Response to the Applicant's Noise Assessment Update

Note by William David Moore

The applicant has submitted a document titled [Written Statement of Oral Case ISH3 \[Appendix F - Noise Assessment Update Note\]](#). In a roundabout way, the applicant's document attempts to justify the absence of attenuation corrections to the sound of train pass bys measured by NMP4.

00:00 on 25/04/2021 to 00:00 on 26/04/2021

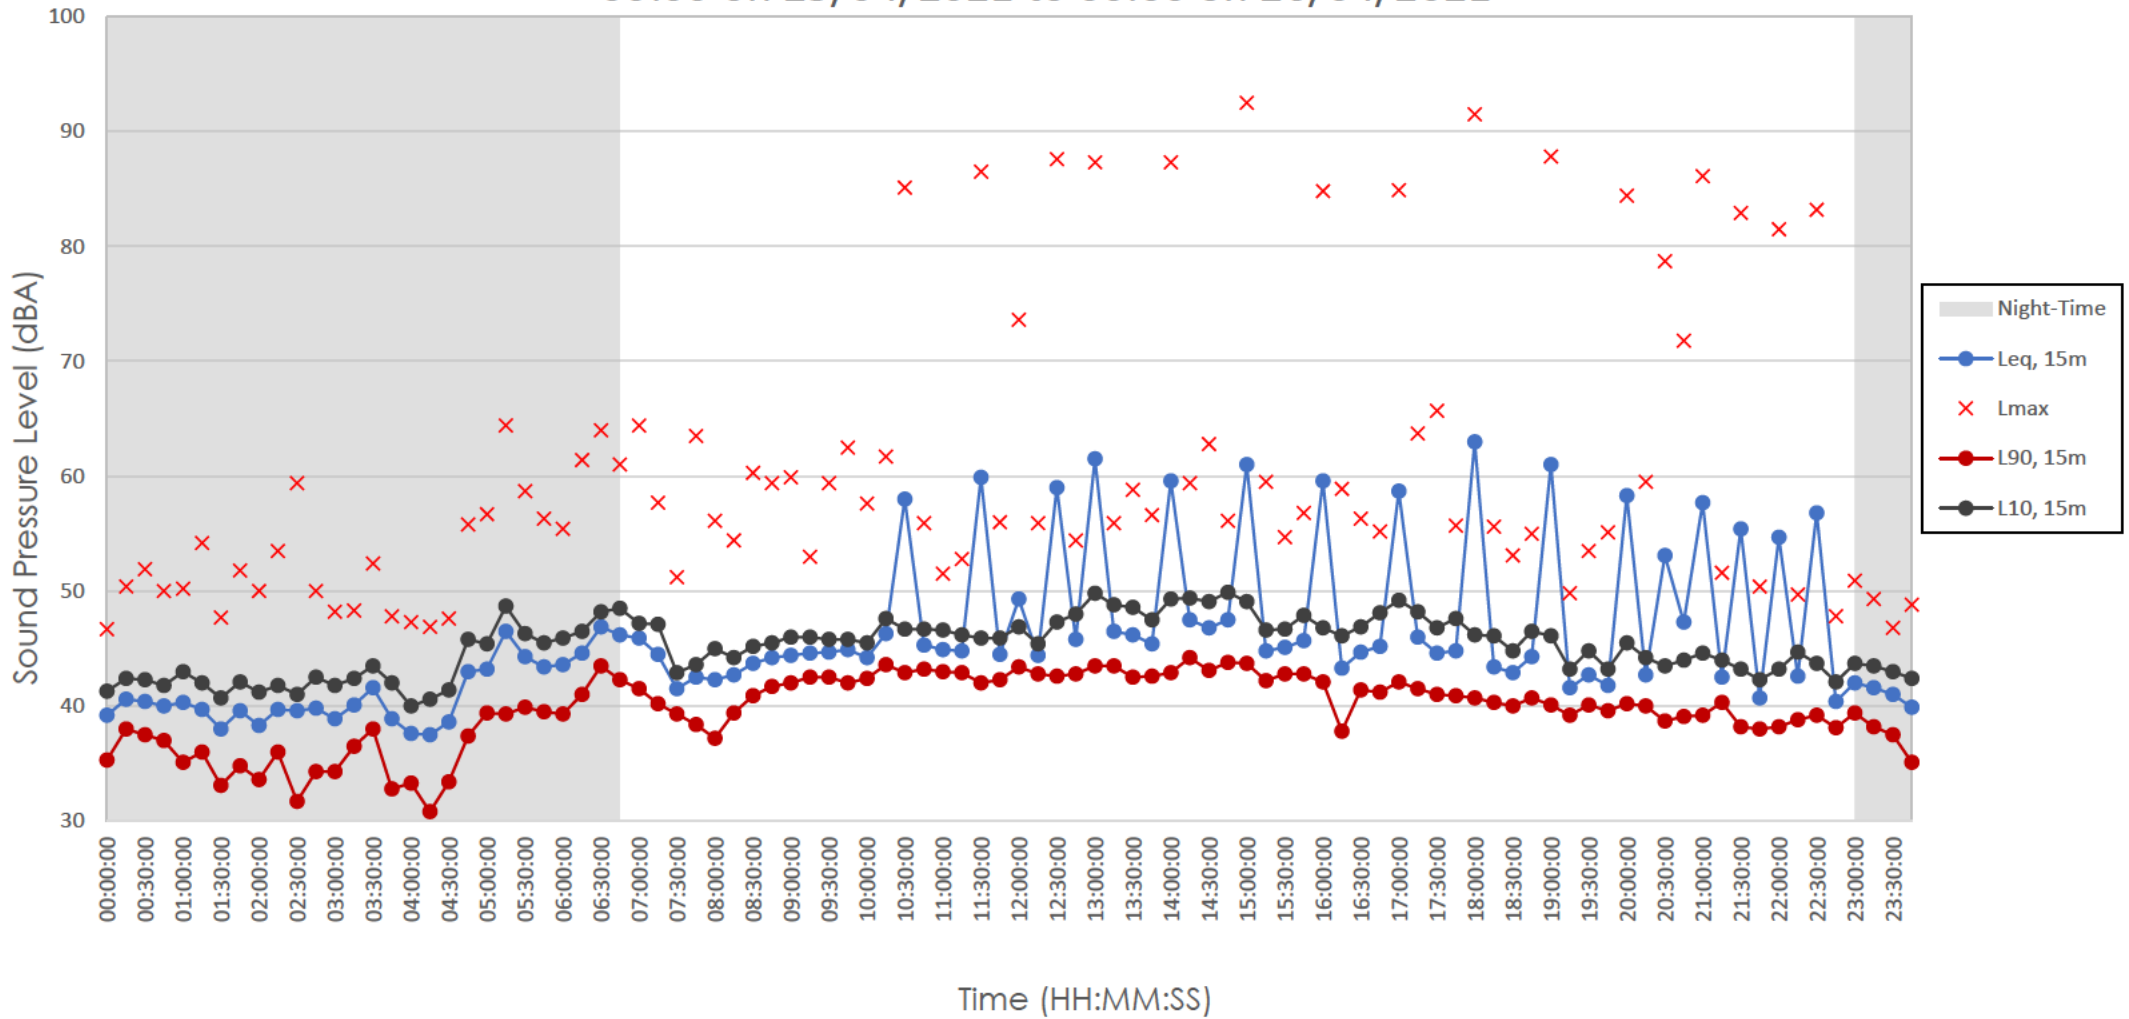
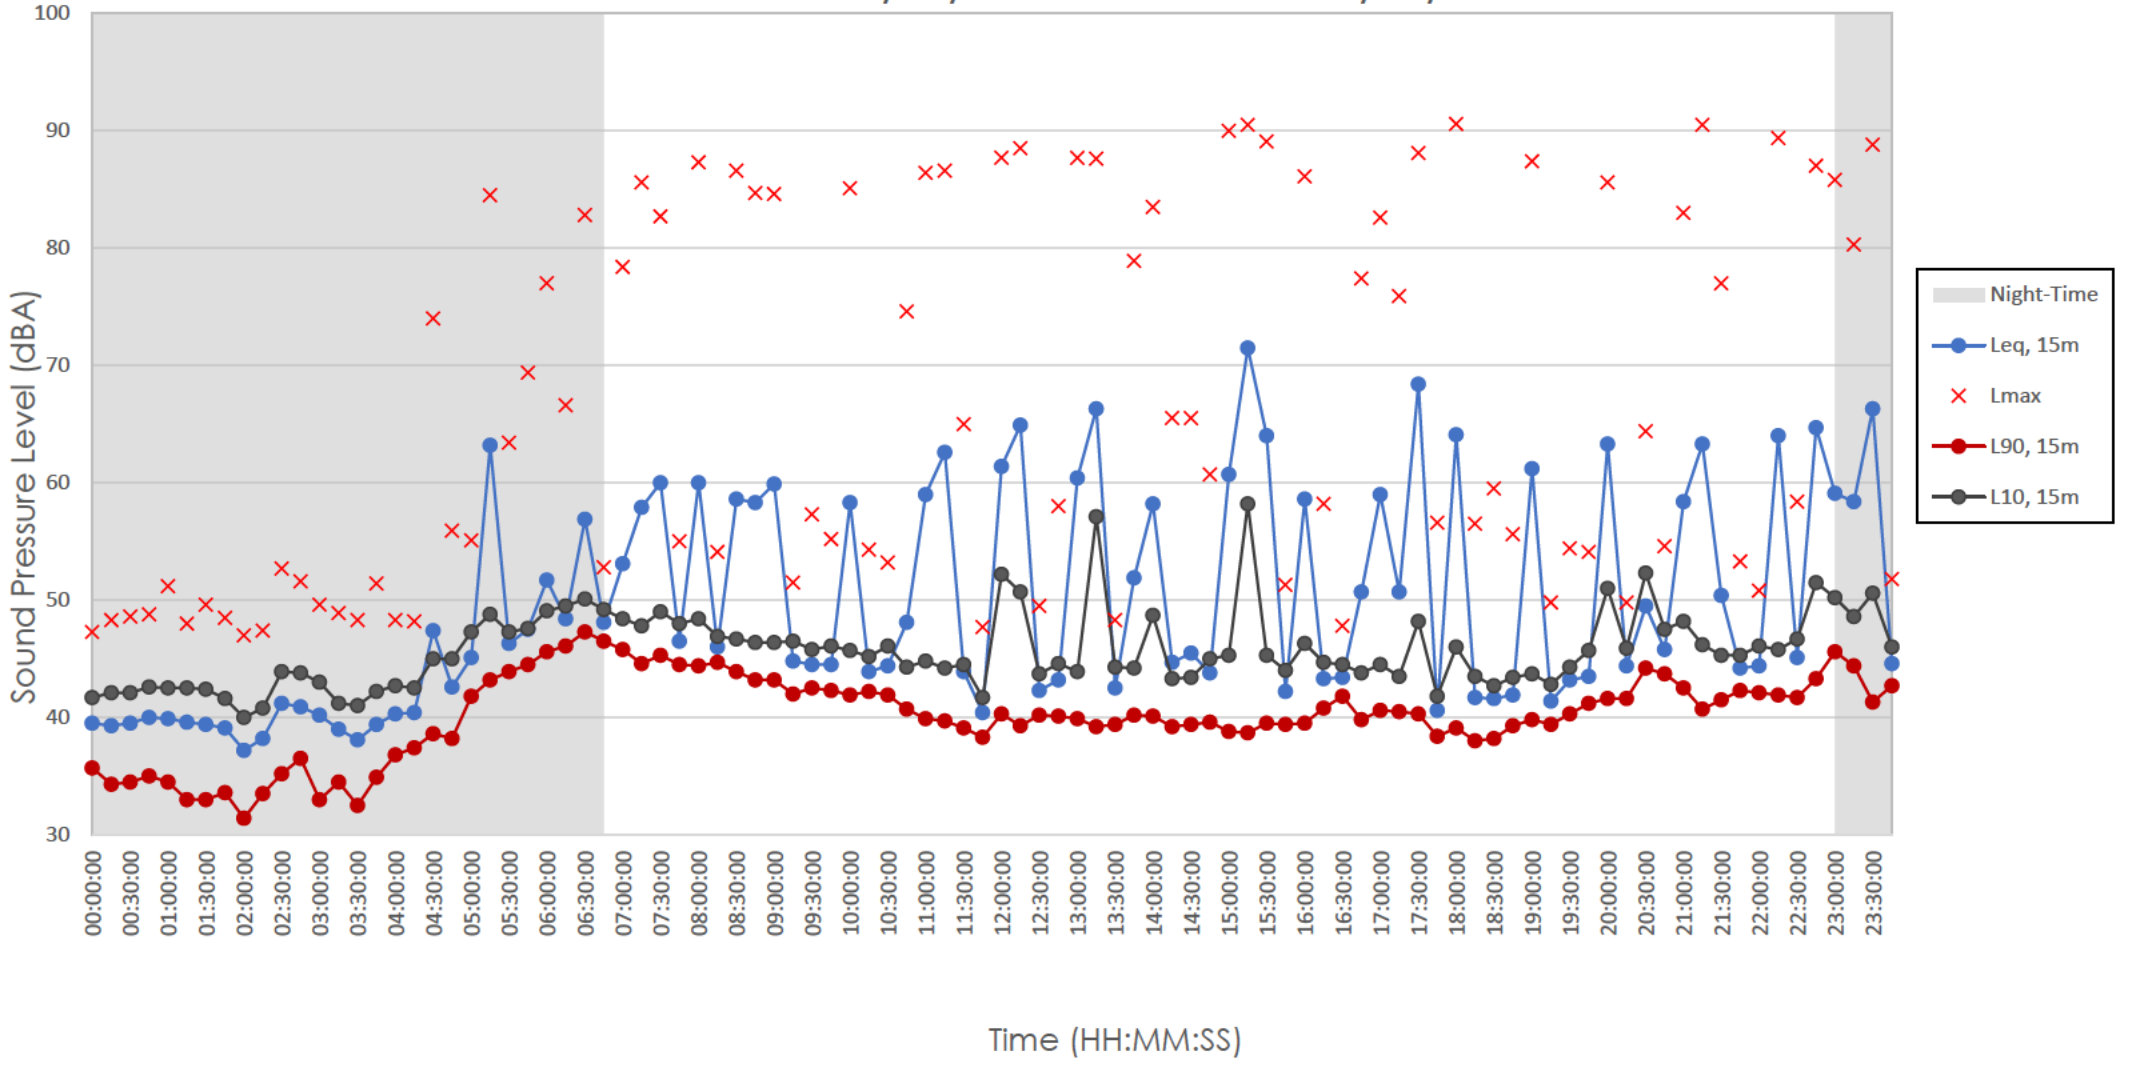
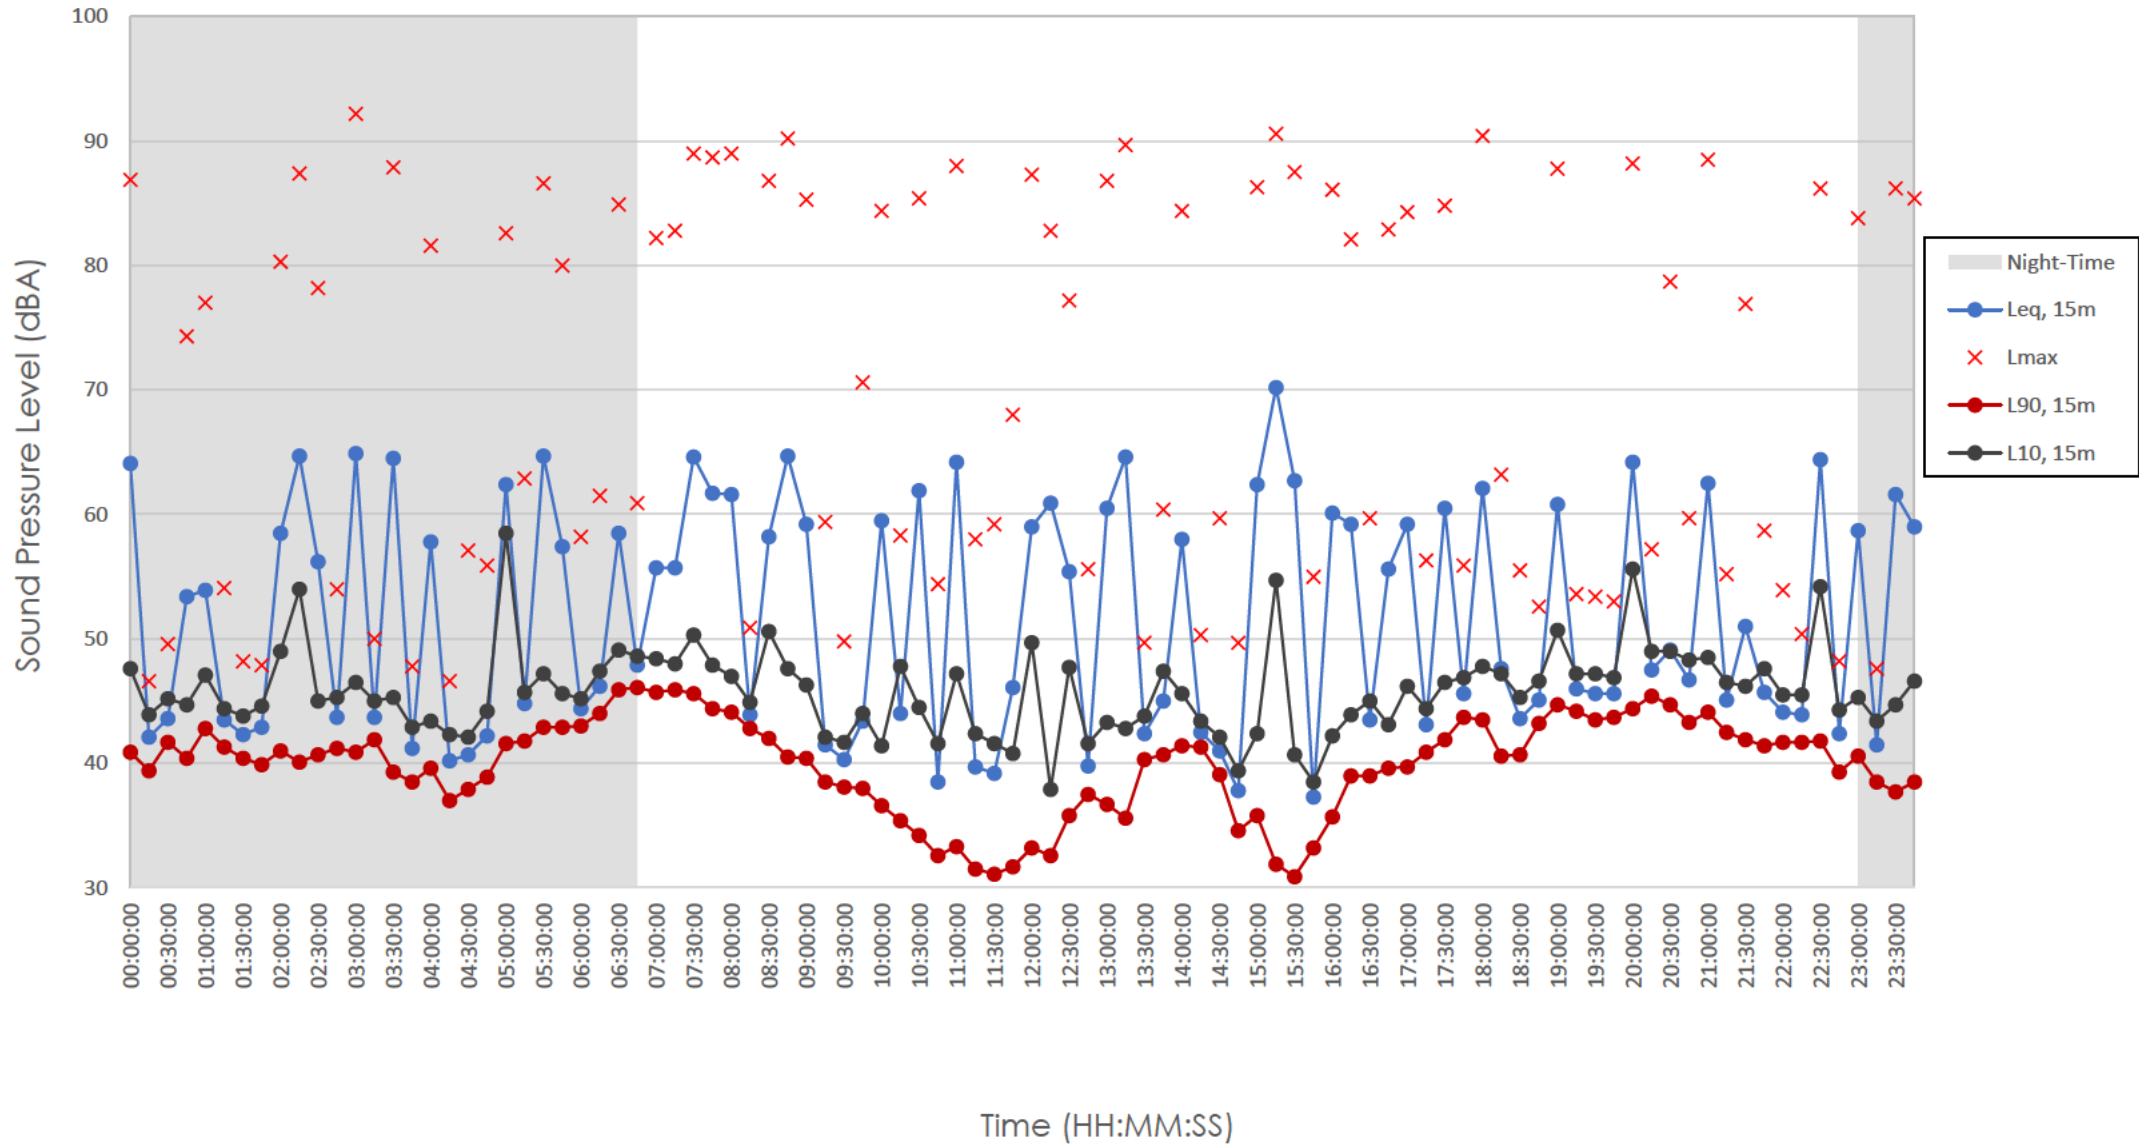
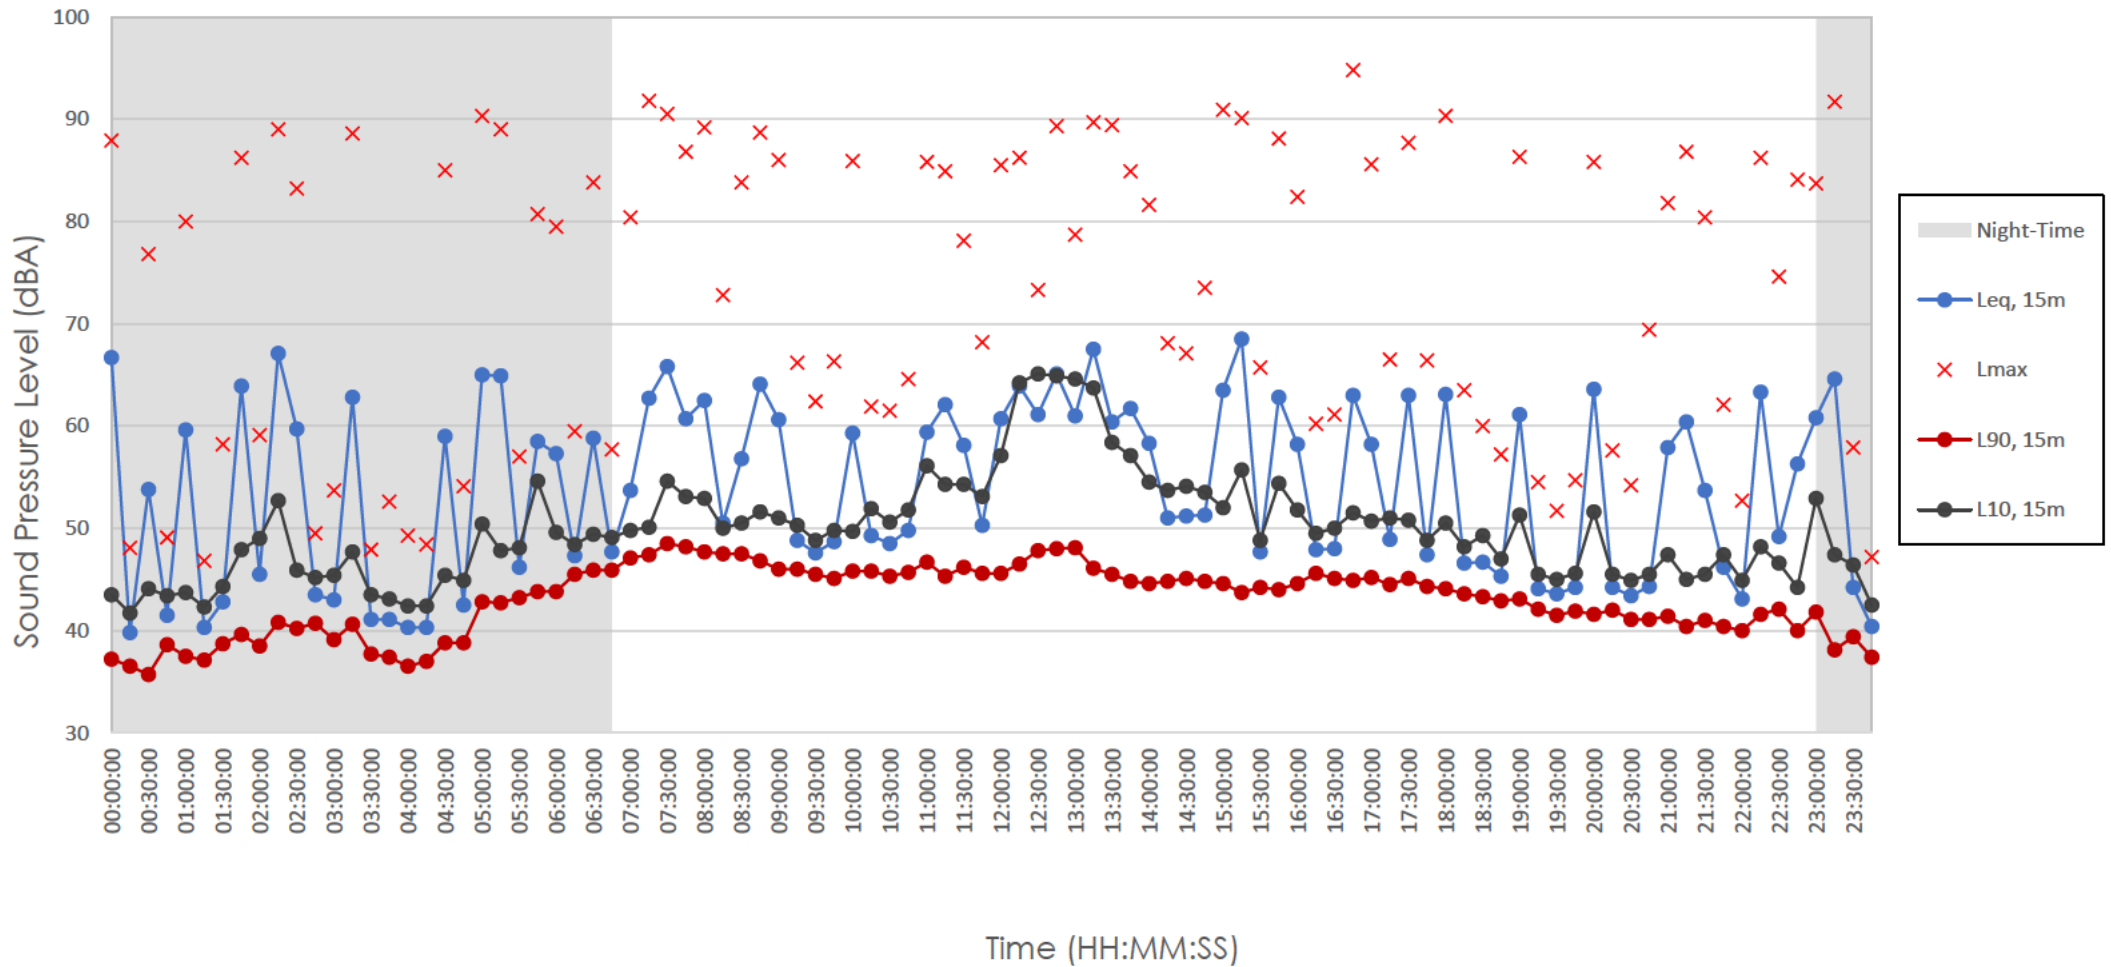
The ambient sound levels measured by NMP4 are utterly dominated by sound of extremely close proximity train pass bys with far lower sound levels when trains aren't passing by, i.e. almost all the time. Overwhelming evidence of this is contained within the summary results pages for NMP4, as explained below in points 1-4. An example summary results page is included in Figure 1, below.

1. The LAeq sound levels repeatedly spike up and down throughout the daytime and night-time by ~15-20 dB from the low-mid forties, up to 55-65 dB. These spikes are caused by the sound of extremely close proximity train pass bys. Distant road noise would not cause these repeated spikes.

2. If these high LAeq sound levels were caused by the distant road noise we would always see the LA10 levels spiking along with the LAeq levels, but we don't because they're caused by train pass bys and train pass bys are inherently brief.

3. If these spikes were caused by changes in the distant road noise, we would see significant changes up and down in LA90 levels, but we don't because they're caused by train pass bys and train pass bys are inherently brief. This is why there's a gap of 20 dB between the weekday daytime background sound level in the report and the weekday daytime ambient sound level in the report. The train pass bys have no impact on the measured background sound levels, which contain the distant road noise. This is why NMP4's measured background sound levels can simply be copied to NSRs 1-8 & 24-26.

4. The spread between the LA90 levels, LAeq levels, and LA10 levels is very tight in those 15 minute periods which don't contain spikes in LAeq levels. This is because these time periods are dominated by the distant road noise in the low-mid forties dB. The gap between the LA90 levels and the LA10 levels remains stable during periods with spikes in LAeq levels because the distant road noise is stable.

We end up with weekday daytime ambient sound levels used in the report for NMP4 of almost 60 dB, which are then applied to NSRs 1-8 & 24-26. This isn't because of distant road noise, it's because of the sound of extremely close proximity train pass bys.

The applicant needs to be returned to the measured sound levels at NMP4 and the applicant needs to apply attenuation corrections to the measured sound of train pass bys to generate ambient sound levels at NSRs 1-8 & 24-26 during weekday daytimes, weekday night-times, weekend daytimes and weekend night-times.
